Susan Leeson
Planning

**LAND ADJACENT TO WALBERTON VILLAGE HALL, THE STREET, WALBERTON –
WA/37/11. RESUBMISSION FOLLOWING WA/12/11/**

Rachel Alderson
Principal Landscape Officer

Tree Constraints Plan

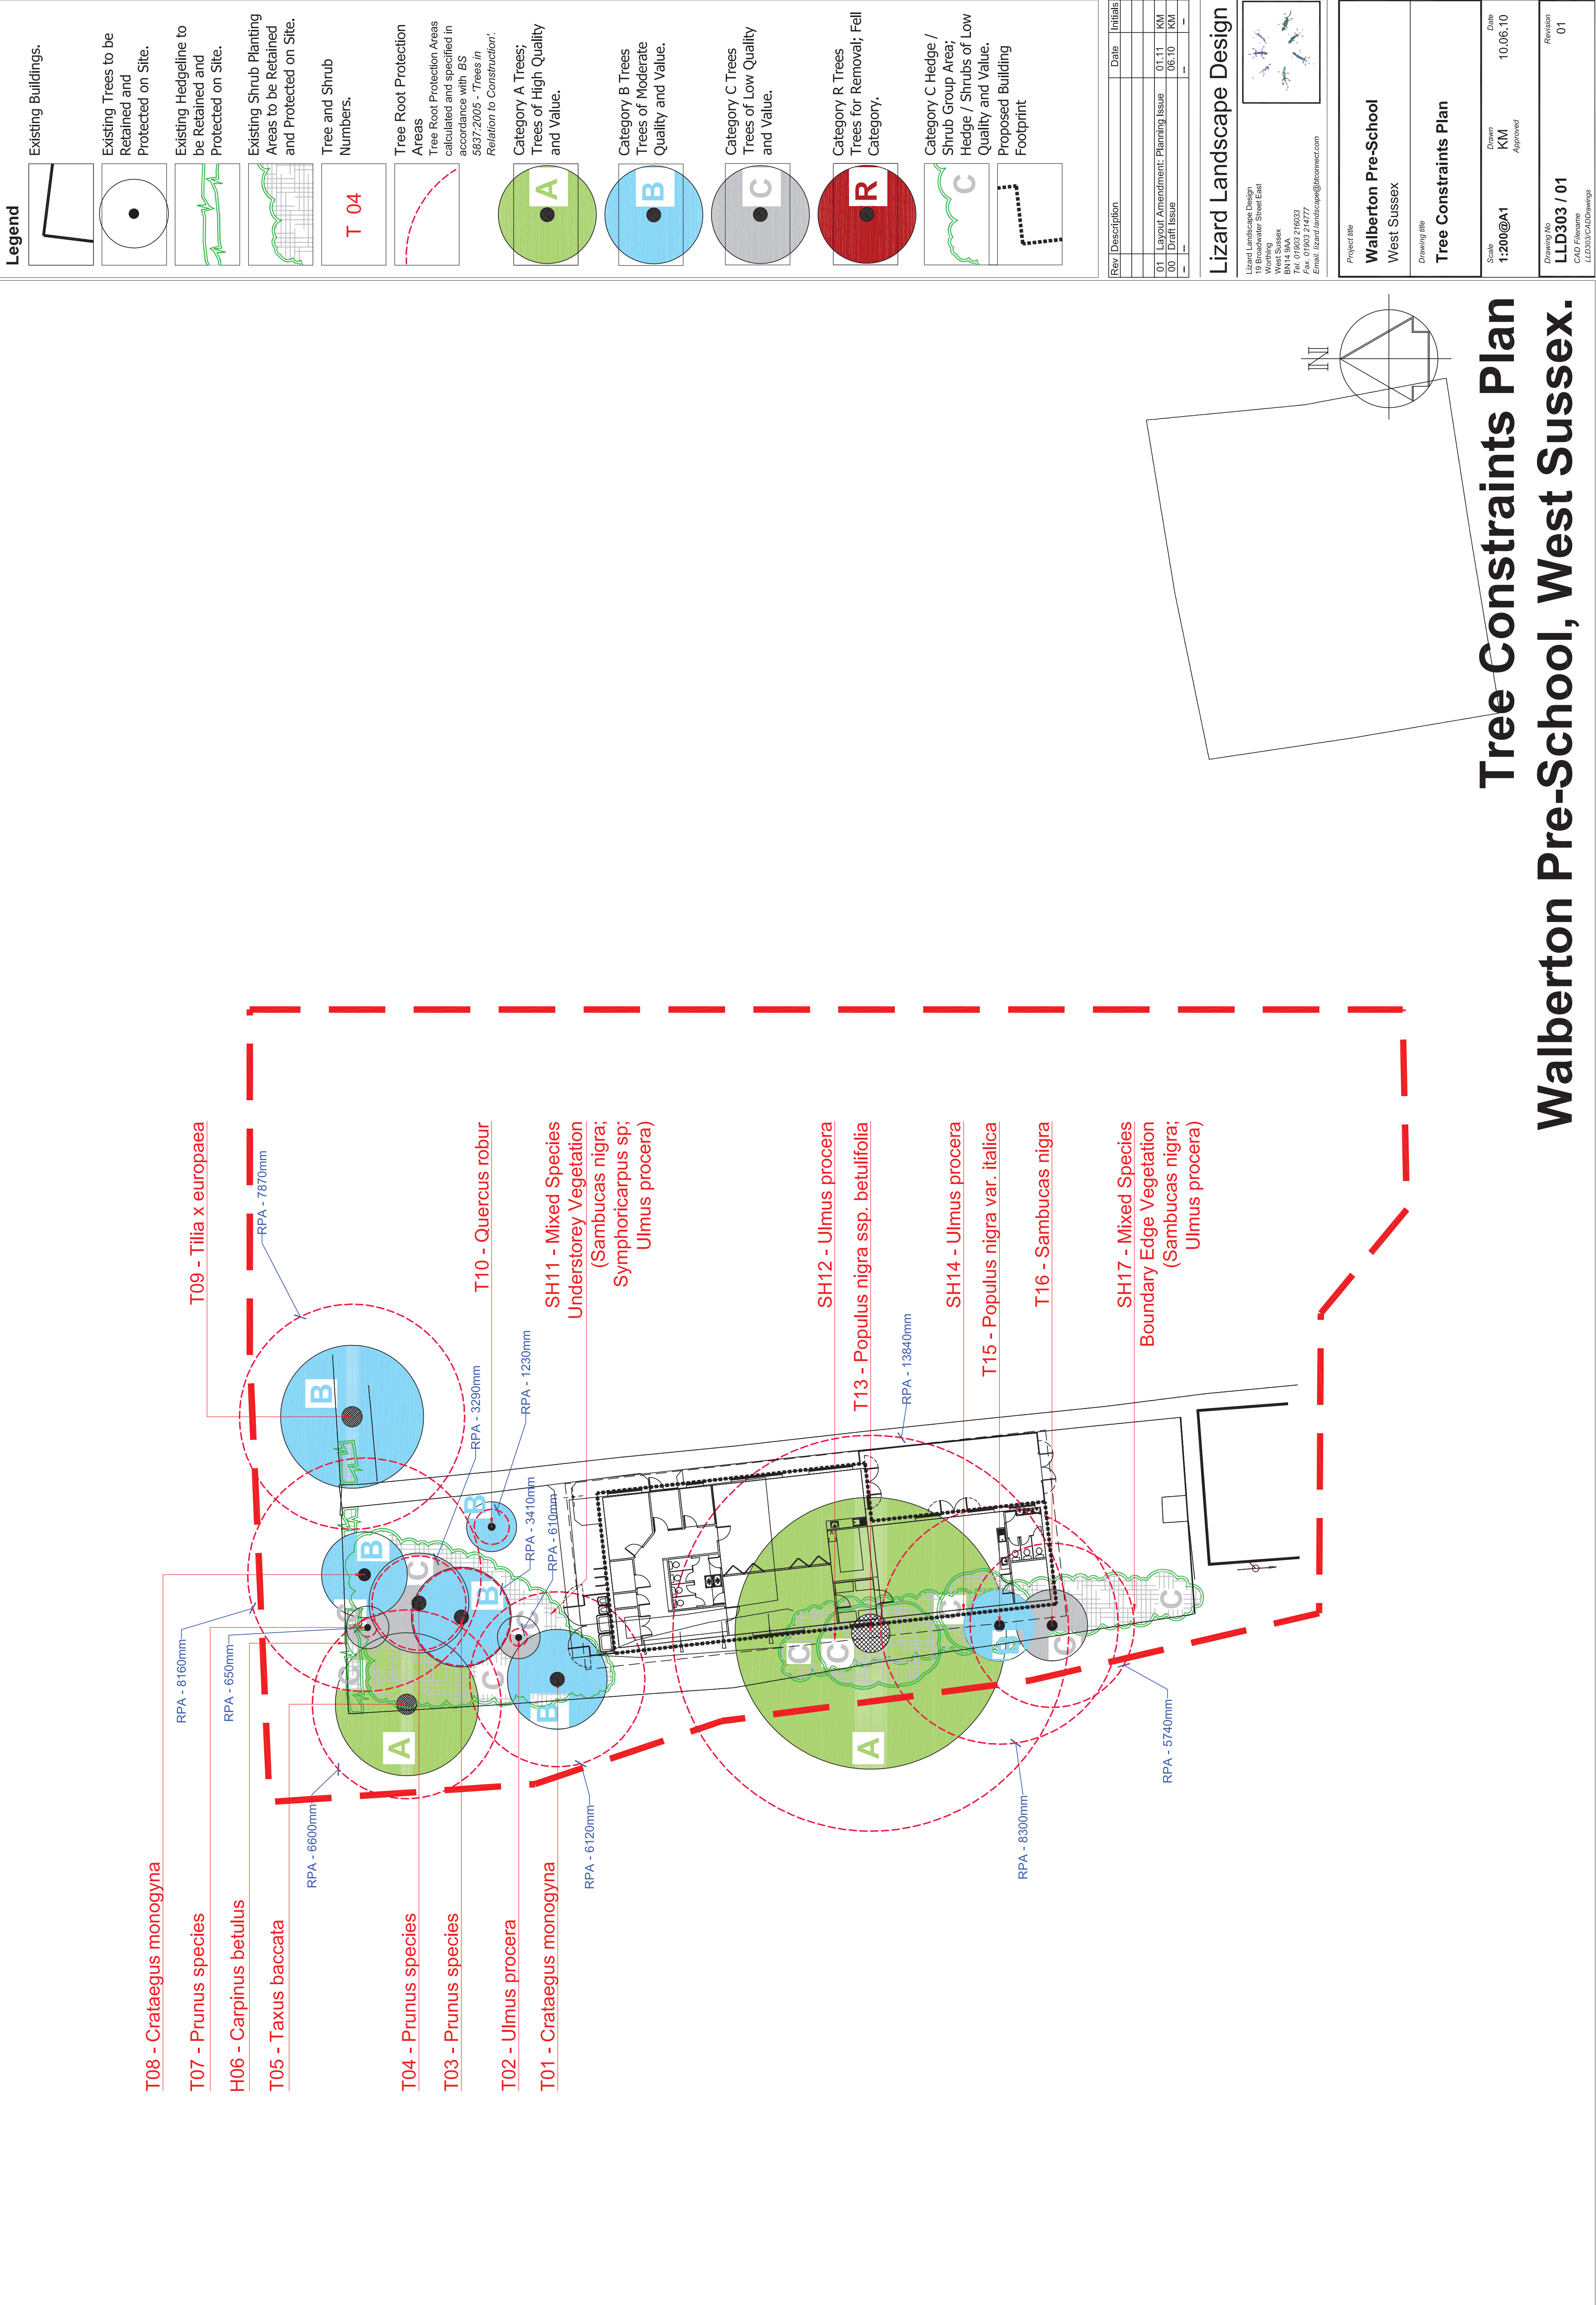
It is noted that the resubmission shows the new building at a reduced size however the Tree Retention and Protection Plan and the Landscape Proposal – Planting Enhancement Scheme Plan have not been updated to reflect this submission. New plans must be submitted which take the new building outline into account.

A number of existing trees are proposed for removal including most notably a black poplar tree. This has been identified as an 'A' grade specimen in the Tree Schedule and Arboricultural Assessment, highlighting its significance on the site. It is one of the largest and most prominent trees on the public open space and is also recognised to have potential for bats. To fell the tree would be detrimental to the amenity value of the area. Other trees proposed for removal, categorised grade 'B' and 'C' also form part of the existing boundary and are an important feature of the recreation ground. The proposed planting, while sensitive to the rural location, does not compensate for the status of the existing trees. It appears that the line of an existing footpath is restricting the available space for the development and creating unnecessary risk to the trees. If the building was to be relocated this problem would not occur.

It will be necessary to seek compensation for the loss of the basketball facility on the development site. The conclusion of bat and reptile surveys will need to be taken into account when determining the application. While the building has been positioned to minimise visual impact, it is being constrained by the line of the existing footpath which is resulting in the unacceptable removal of a significant tree. On this basis the application should not be approved or at a minimum seek mitigation which incorporates compensatory planting to the east of the development and which reflects the importance of the trees intended for removal. New Tree Protection and Landscape Proposal drawings are required which show the current building proposal.
